**Application for a non-material amendment following a grant of planning permission.
Town and Country Planning Act 1990**

RESIDENTIAL DEVELOPMENT - 8 DWELLINGS INCLUDING PRIVATE DRIVE
APPROVED UNDER H23-0535-18. MODIFICATION OF CONDITION 2 TO
ALLOW AMENDMENTS TO PREVIOUSLY APPROVED PLANS - APPROVED UNDER
H23-0118-21. AMENDMENTS TO BUNGALOW DESIGN TO PLOT 4.

AMENDMENTS RESTRICTED TO PLOT 4
FOOTPRINT UNAFFECTED
AMENDMENTS TO INTERNAL LAYOUT WITH RESULTANT CHANGES TO FENESTRATION
AND DOOR OPENINGS - SINGLE INTEGRAL GARAGE OMITTED AND REPLACED
WITH BEDROOM AND EN SUITE.
ROOF PITCHES REDUCED AND ROOF LIGHTS OMITTED

date Nov 2020
scale(s) 1: 250
DRG. No.
SLD /pl/ Landscape Rev B

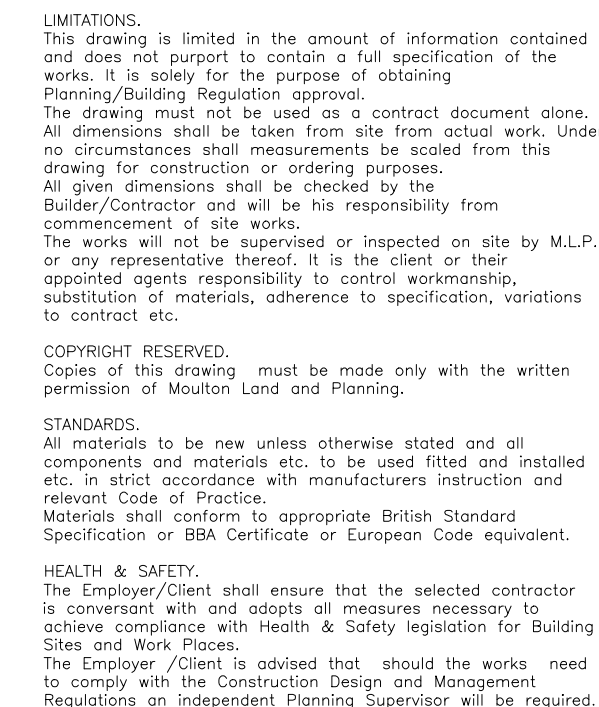
AMENDED BUNGALOW DESIGN-DRG SLD/PI/PL REV-02 ; SITE LAYOUT SLD/PI/LANDSCAPE REV B
